Report of the meeting of the Development Control Post-Committee Site
Inspection Panel held on 06-MAR-2012

REF NO: **BE/151/11/**

LOCATION: Land South of Shripney Garden Caravan
 Park, Shripney Lane
 Bognor Regis

PROPOSAL: Extension to existing caravan park to provide 12no. additional mobile homes,
 associated parking area, formation of access and construction of electrical
 intake housing - Amendment to application BE/42/10

Revision A - positions of mobile homes are indicative only 6/12/12
SHRIPNEY GARDEN CARAVAN PARK, SHRIPNEY
Proposals 01 A

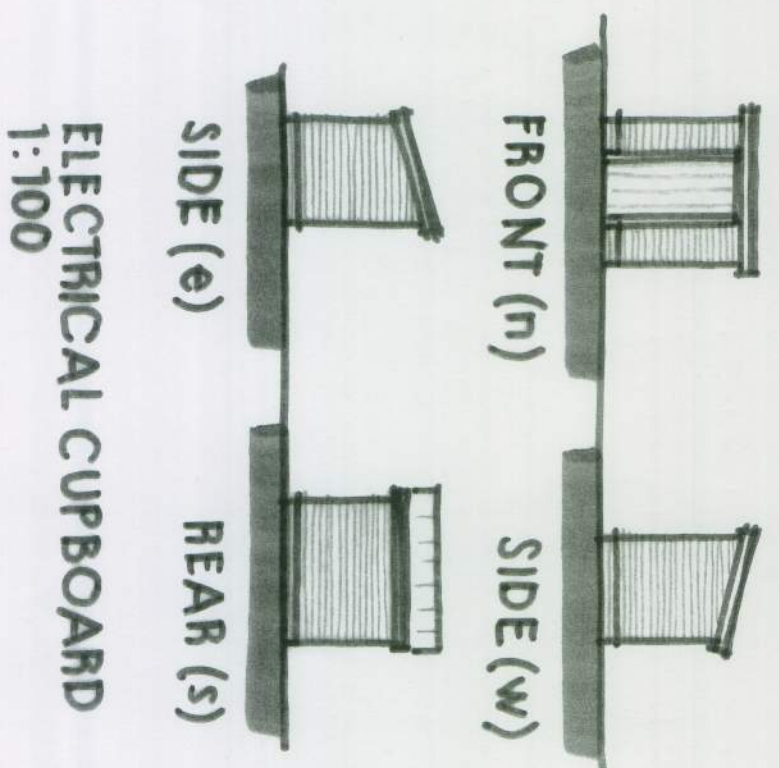
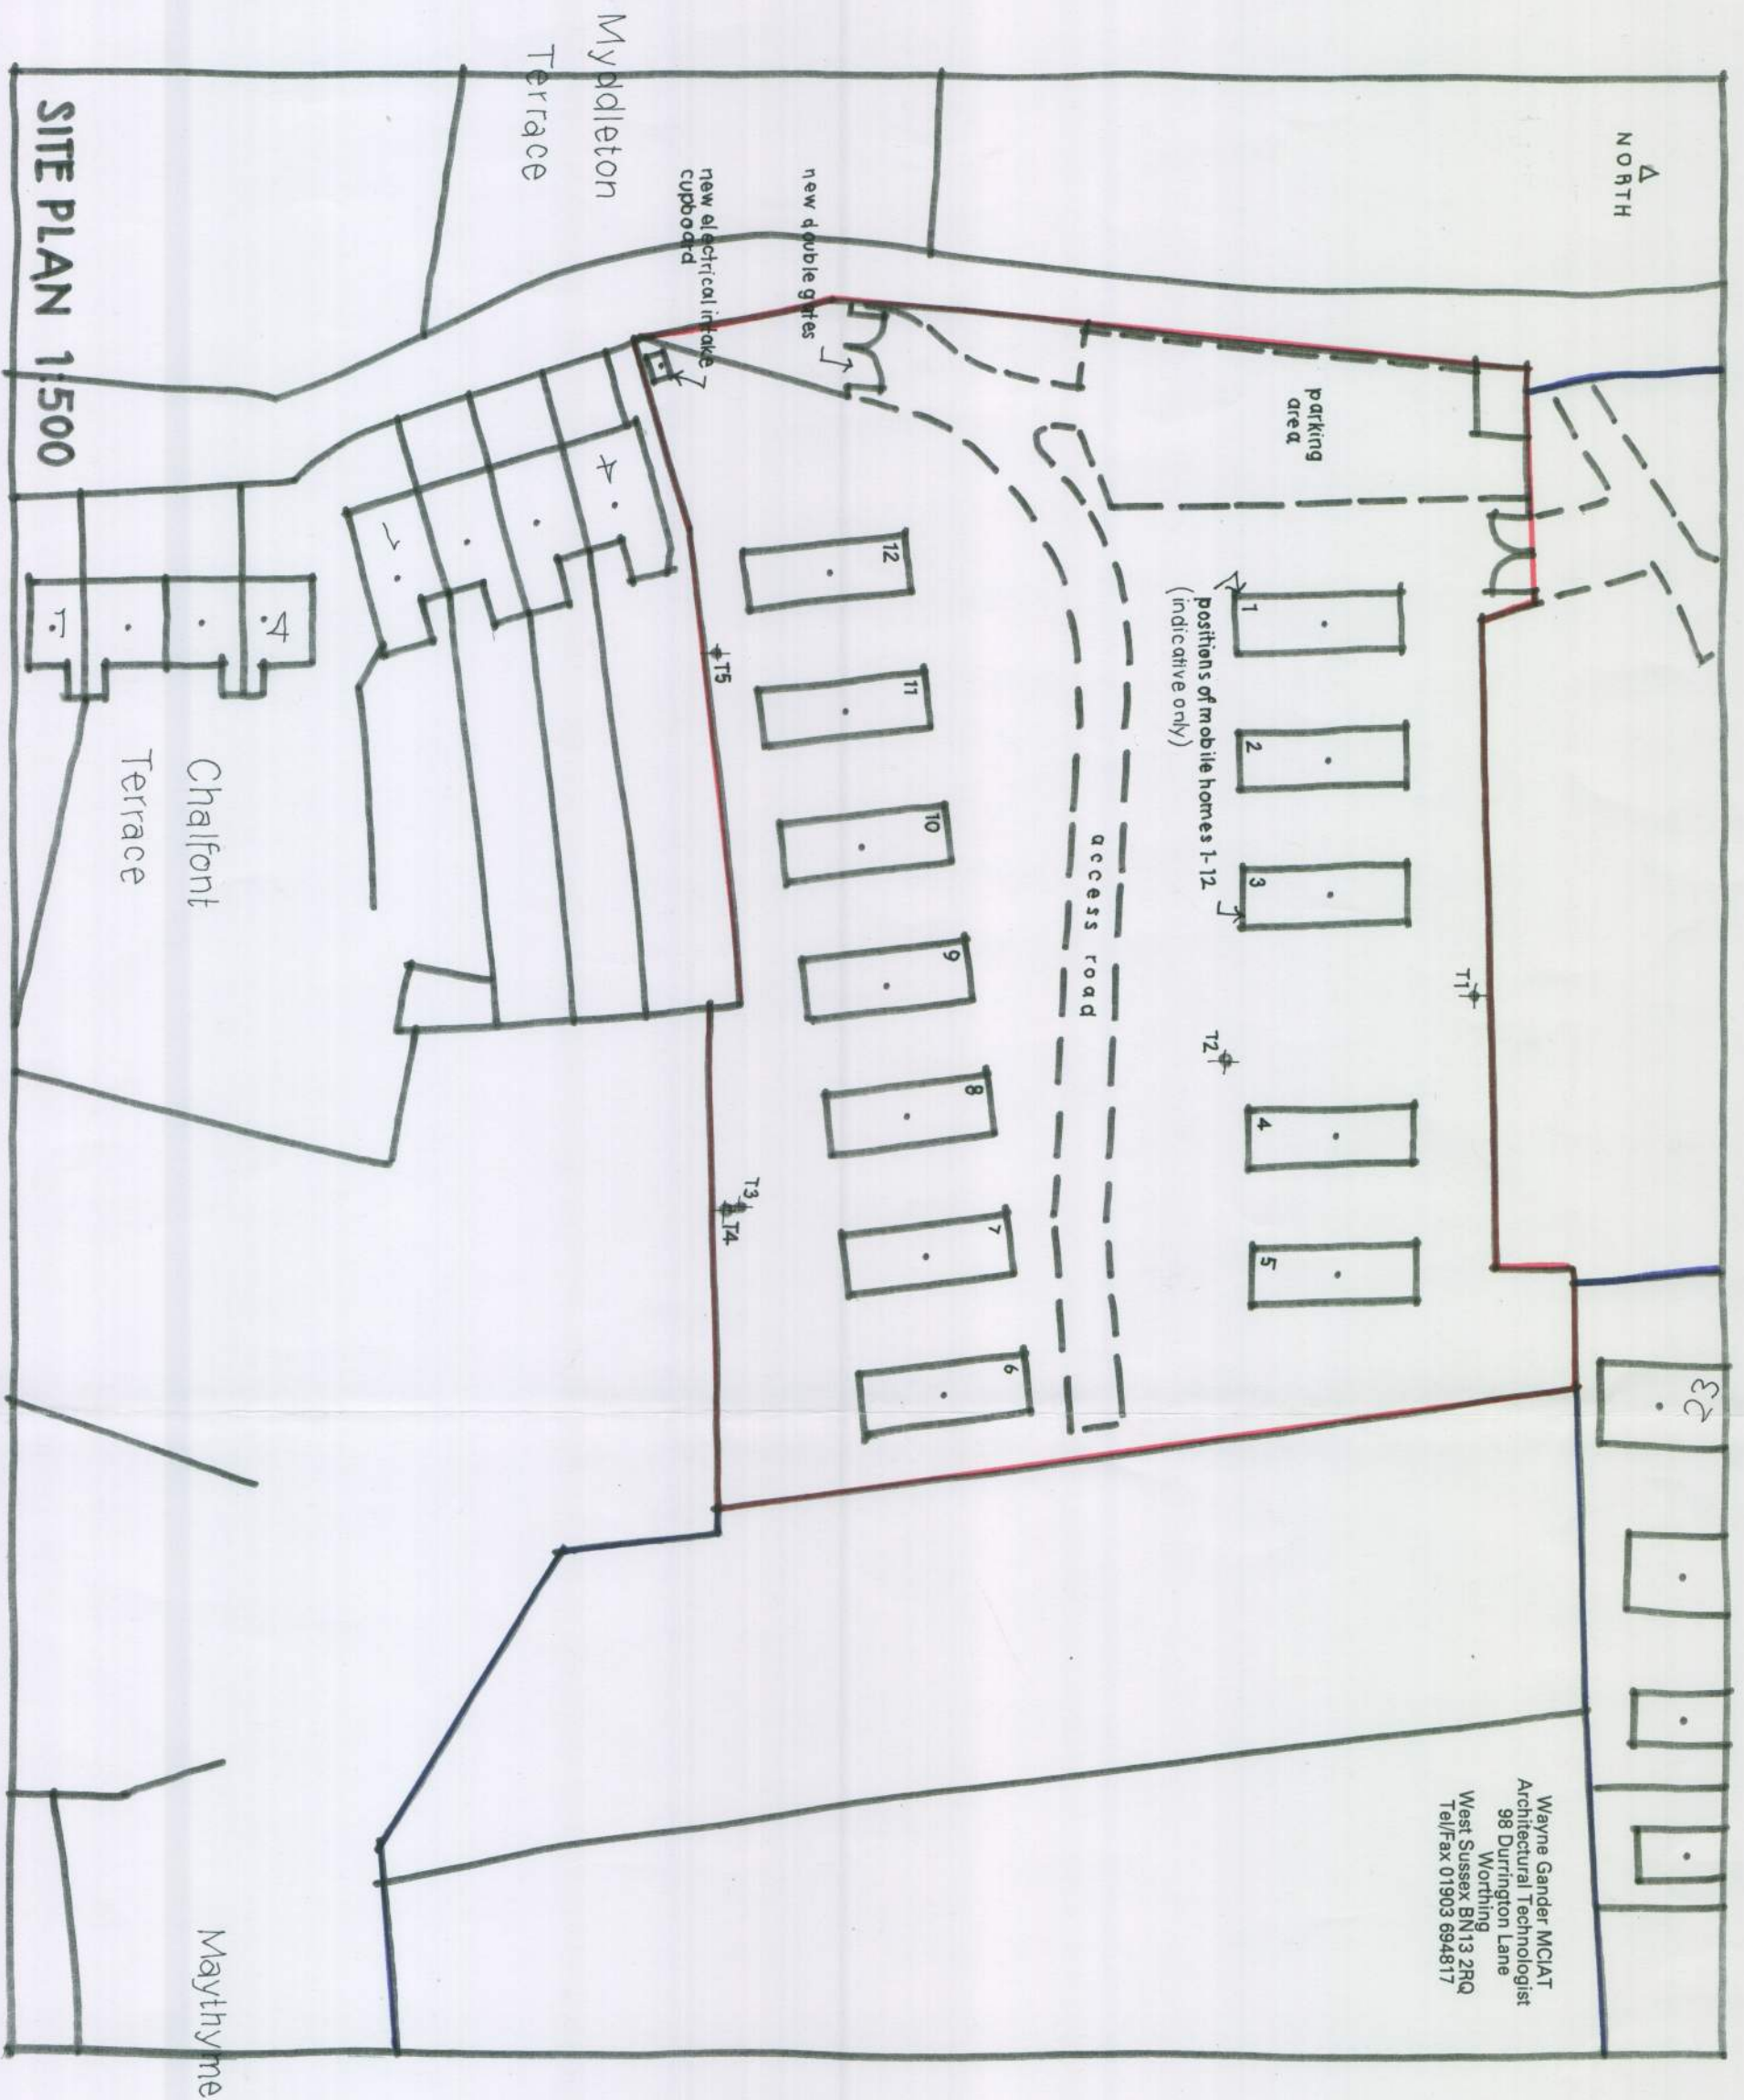
The side boundary of the site to the east has been extended by approximately 17m. It would appear that this is to protect the position of 2 trees to the north. This has resulted in caravans 10, 11 and 12 being moved closer to Myddleton Terrace. The layout of the parking area has changed as well as the access. A new electricity cupboard 2m x 1.5m has been erected on the front boundary.

SHRIPNEY GARDEN CARAVAN PARK, SHRIPNEY LANE, SHRIPNEY
Proposals 01 B
Nov 2011

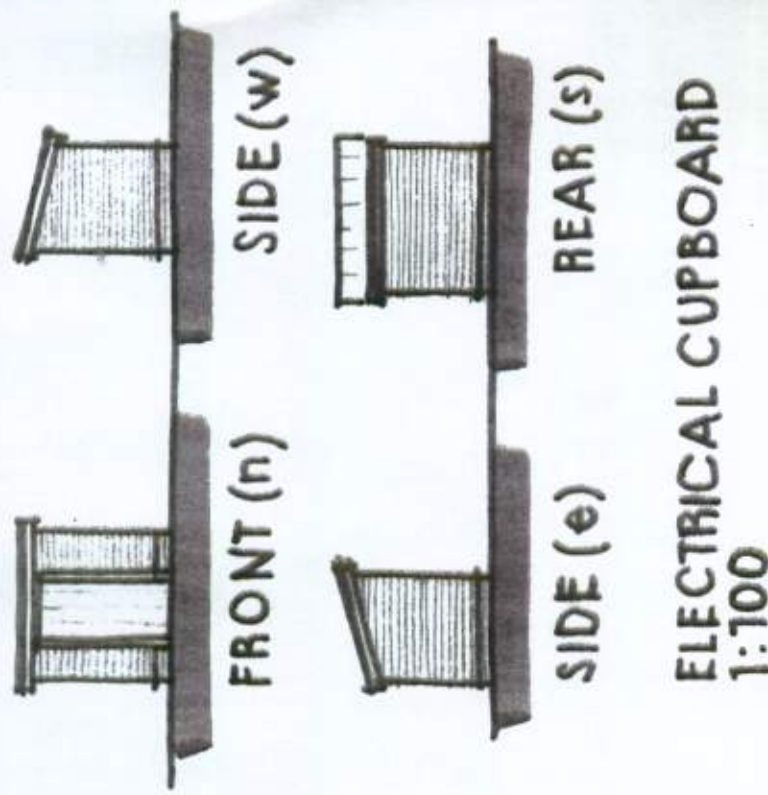
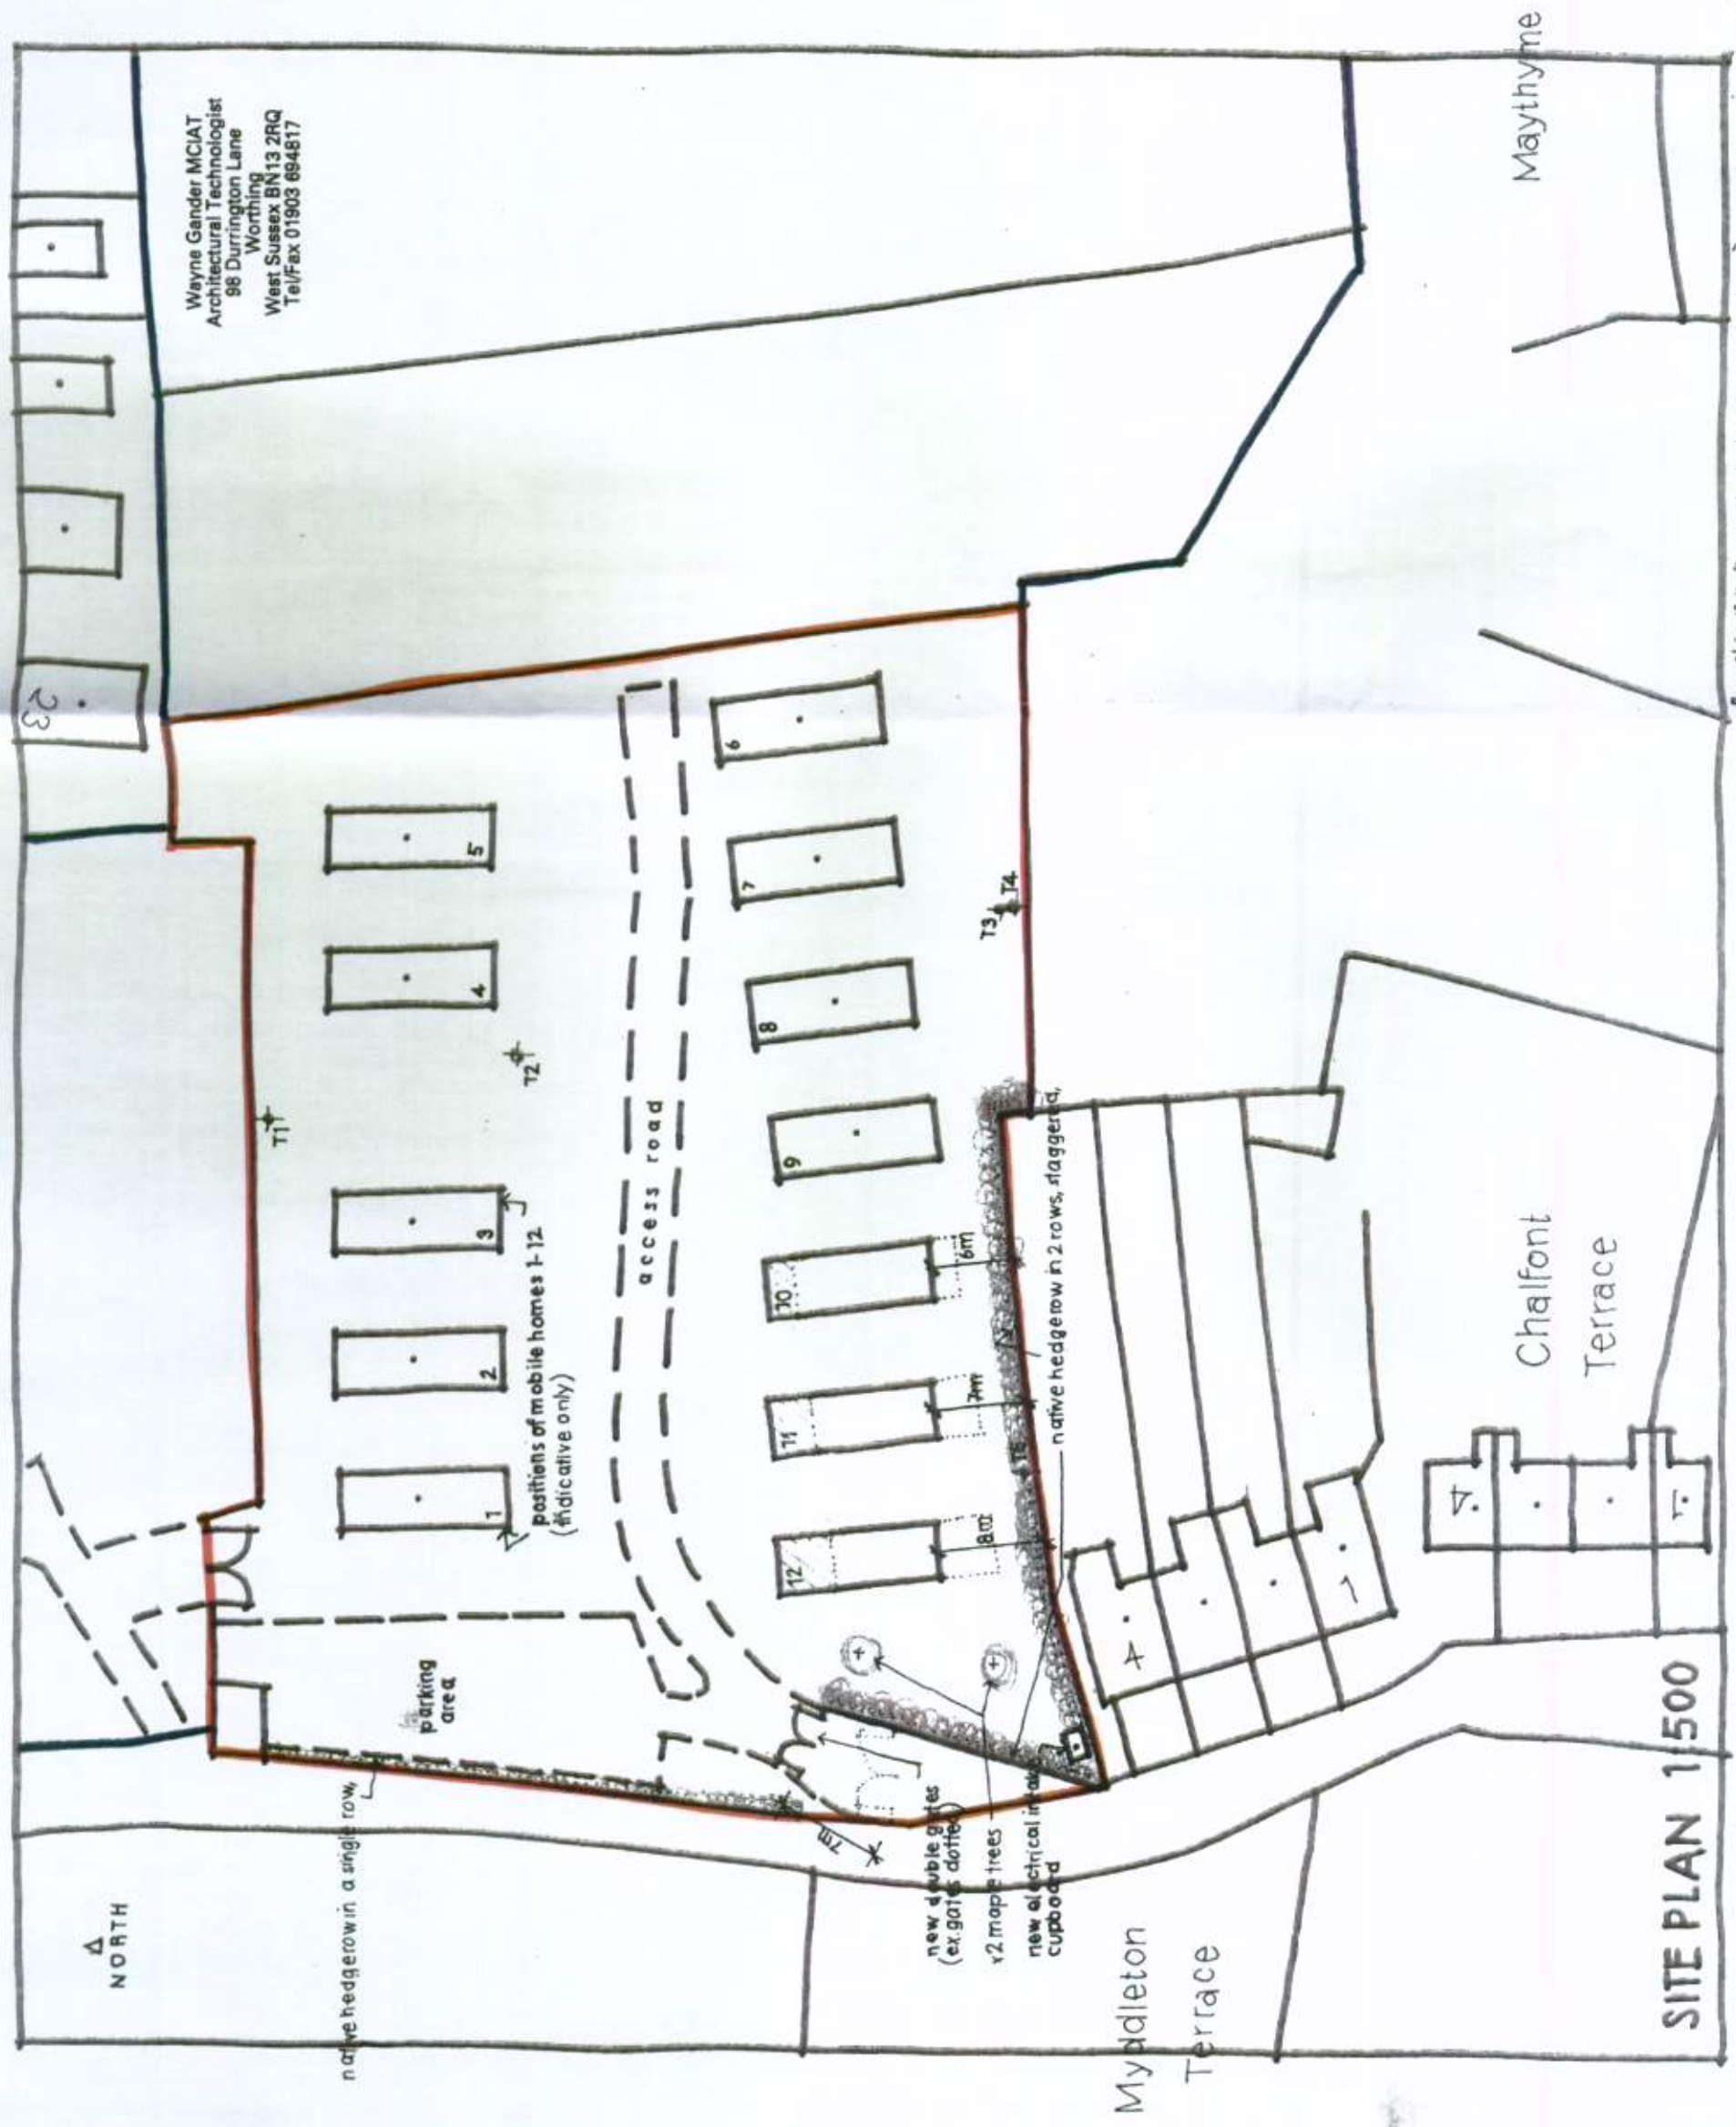
As stated above the layout of the site is subject to the Caravan License and for planning purposes is indicative only. However it is considered that units 10, 11 and 12 were laid out on bases which were closer to the residential properties than previously shown. It is considered that the closeness to the residential dwelling would result in an increased potential for nuisance to the residents of 4 Myddleton Terrace. This was raised with the Applicant who agreed to move the bases back to the previous location for these 3 units and a substitute plan has been submitted and as stated above landscaping has been proposed to be increased along the side boundary with Myddleton Terrace.

The access gates have been proposed to be moved further into the site to prevent any cars opening the gates waiting on the hard standing close to the residential property. The electricity cupboard will be partly screened by the proposed landscaping.

- 2 The moving of the bases 10, 11, and 12 as indicated on Plan 01B, shall be made within 3 months of the date of this approval, and shall remain in perpetuity in these positions unless otherwise agreed with the Local Planning Authority in an application on that behalf.

- 3 Landscaping shall be carried out in accordance with the details shown on the site plan (proposals 01B) and the planting schedule in the agents letter dated 13th January 2012. All planting, seeding or turfing comprised in the approved details shall be carried out in the first planting and seeding seasons prior to the occupation of the caravans, and any trees or plants which within a period of 5 years from the completion of the development die, are removed or become seriously damaged or diseased shall be replaced in the next planting season with others of similar size and species, unless the Local Planning Authority gives written consent to any variation.
